**Contact:** Fenella Stacey  
**Tel:** 01992 588 483  
**Email:** [ecology@hertfordshire.gov.uk](mailto:ecology@hertfordshire.gov.uk)  
**Date:** 15 December 2023

**Application:** Demolition of existing buildings and erection of 14 dwellings.  
**Address:** Wells Farm, Northaw Road East, Cuffley, Potters Bar, Herts. EN6 4RD  
**Application No:** [6/2020/3451/MAJ](#)

### **ECOLOGICAL IMPLICATIONS**

Schematic GCN Mitigation and Habitat Compensation

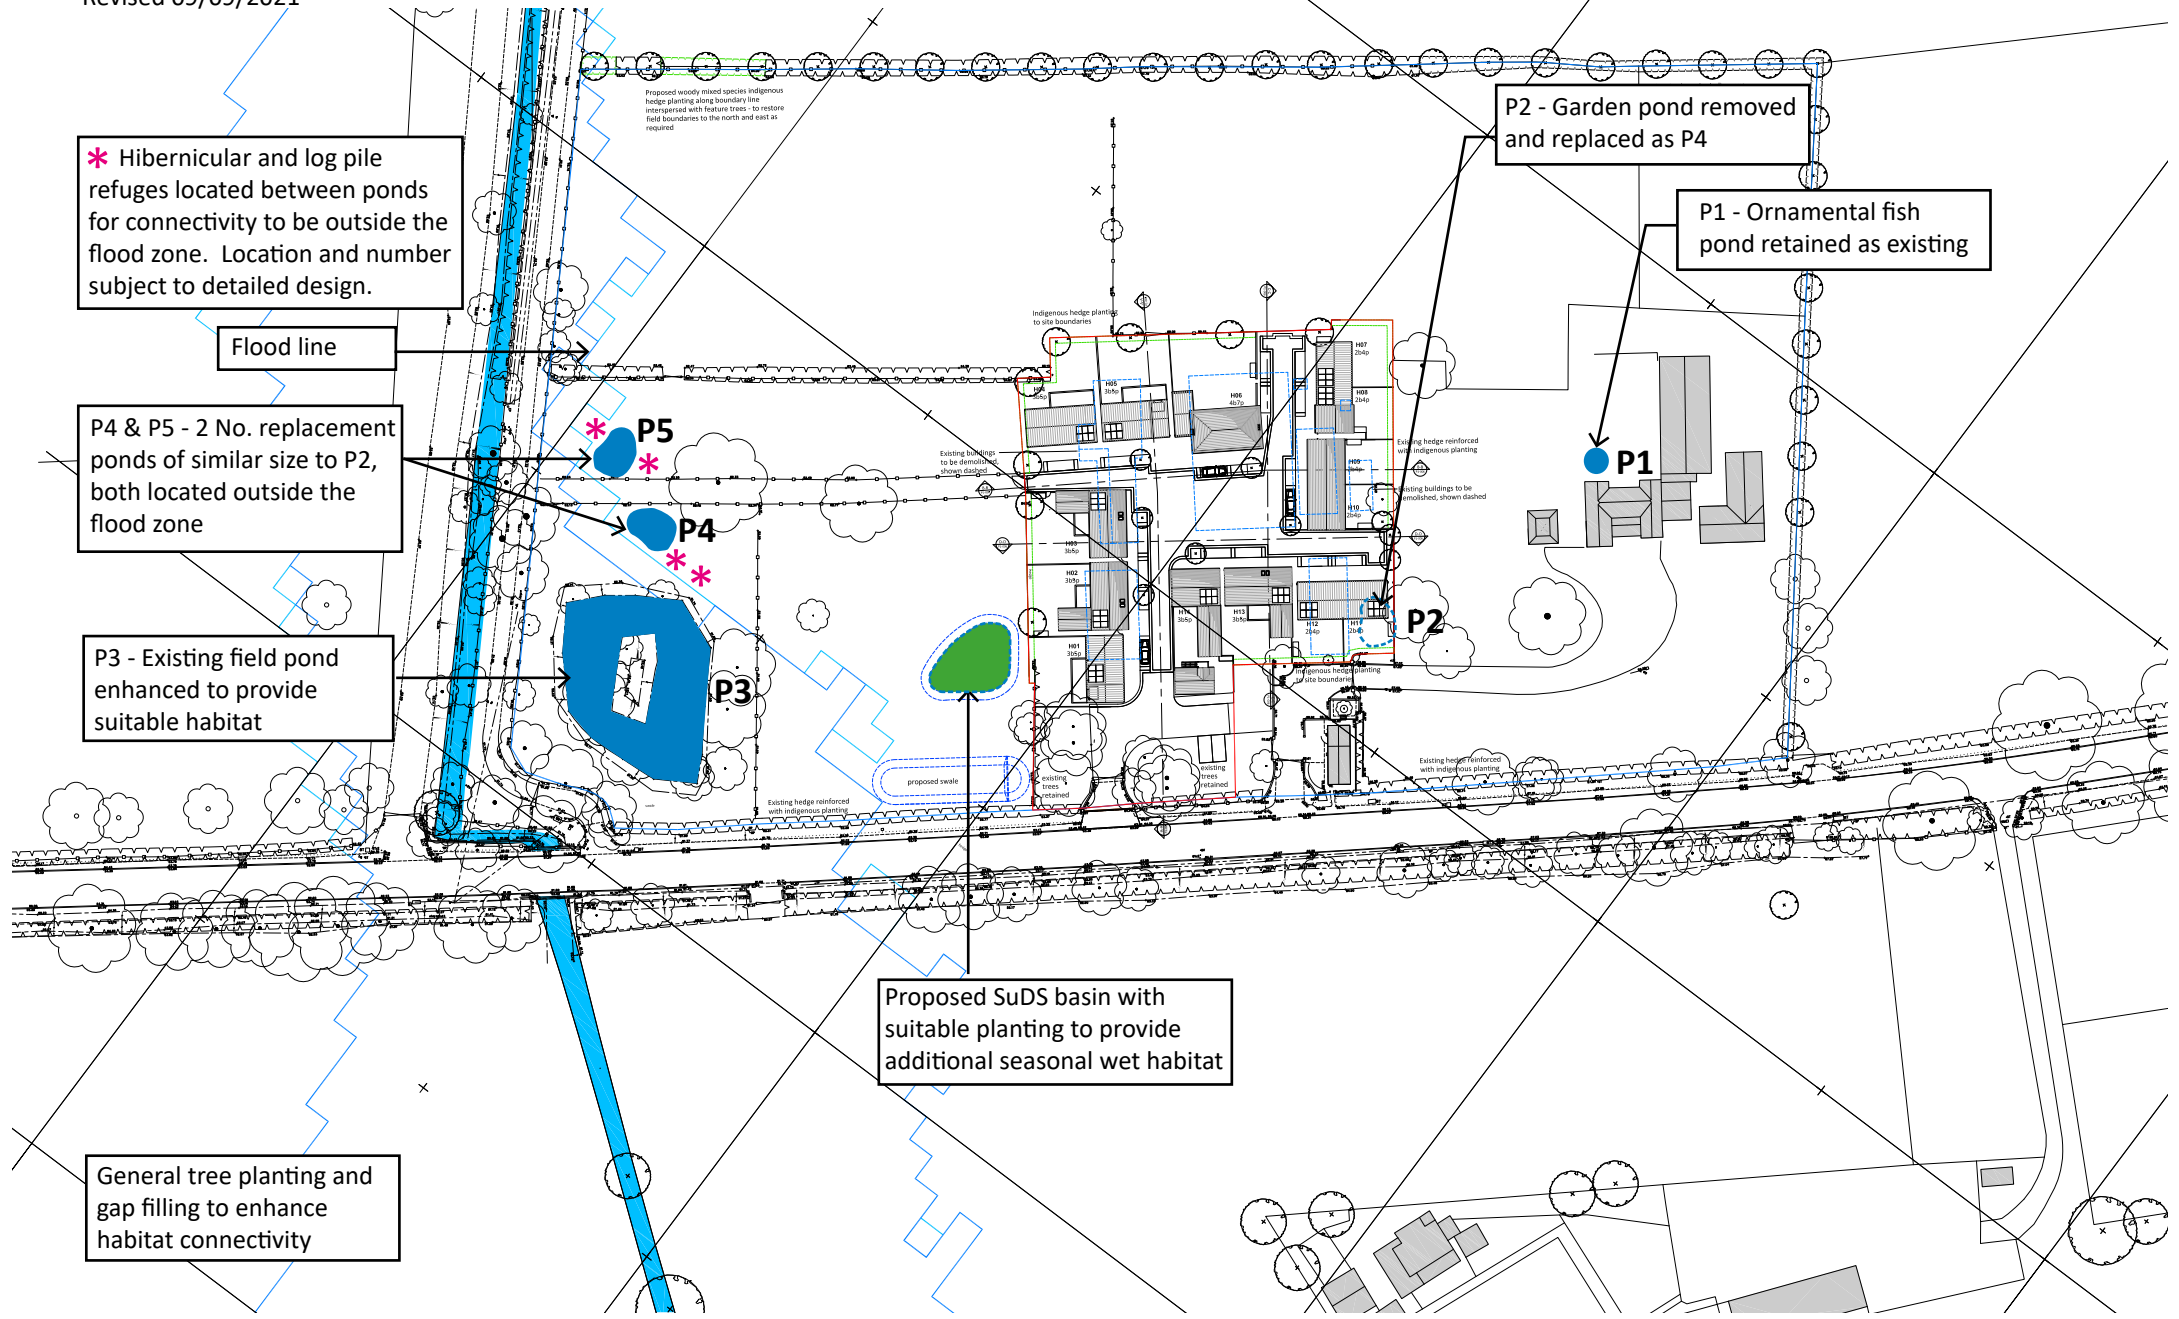
- Revisions to the BNG plan need to be made to include GCN habitat creation.
- A Condition for an updated Biodiversity Gain Plan.

The Net Gain Plan states that the trading rules have not been satisfied as the need to remove a pond on site (a priority habitat) should require compensation with the same habitat type. This has not been satisfied because the metric states that two compensatory ponds will be created as part of SUDS, but these do not meet the same distinctiveness score. They will also need to have permanent water if they are to be suitable for Great crested newt breeding. However, the additional ponds and adjacent habitat creation (under GCN mitigation licence) on western adjacent land within the site owner's boundary is not currently included in the metric. Once the design for the off-site GCN habitat provisioning (both terrestrial habitat and aquatic) has been confirmed, this should be incorporated accordingly into a revised metric as stated within 6.3.2 of the current Gain Plan, which will also inform an appropriately updated Biodiversity Gain plan. The existing Gain Plan does not describe seed mixes for the Other Neutral Grassland, or their management over 30 years, which must also take into account its location beneath mature trees.

On this basis I advise that any permission granted for this application is done so with the following Condition for a Biodiversity Gain Plan. This should demonstrate how the habitat creation and enhancement will be delivered and secured on-site for long-term biodiversity benefit. This would supersede the previous LEMP condition advised.

“Development shall not commence until an updated biodiversity gain plan (BGP) has been submitted to, and approved in writing by, the local planning authority. The content of the BGP shall be informed by an updated metric to ensure the delivery of a minimum of 10% net gain in biodiversity and should also include habitat management plans for the GCN pond and terrestrial habitat creation. The Biodiversity Gain Plan shall take account of the principles within the latest submitted Biodiversity Net Gain Plan (dated November 2023), and include the following:
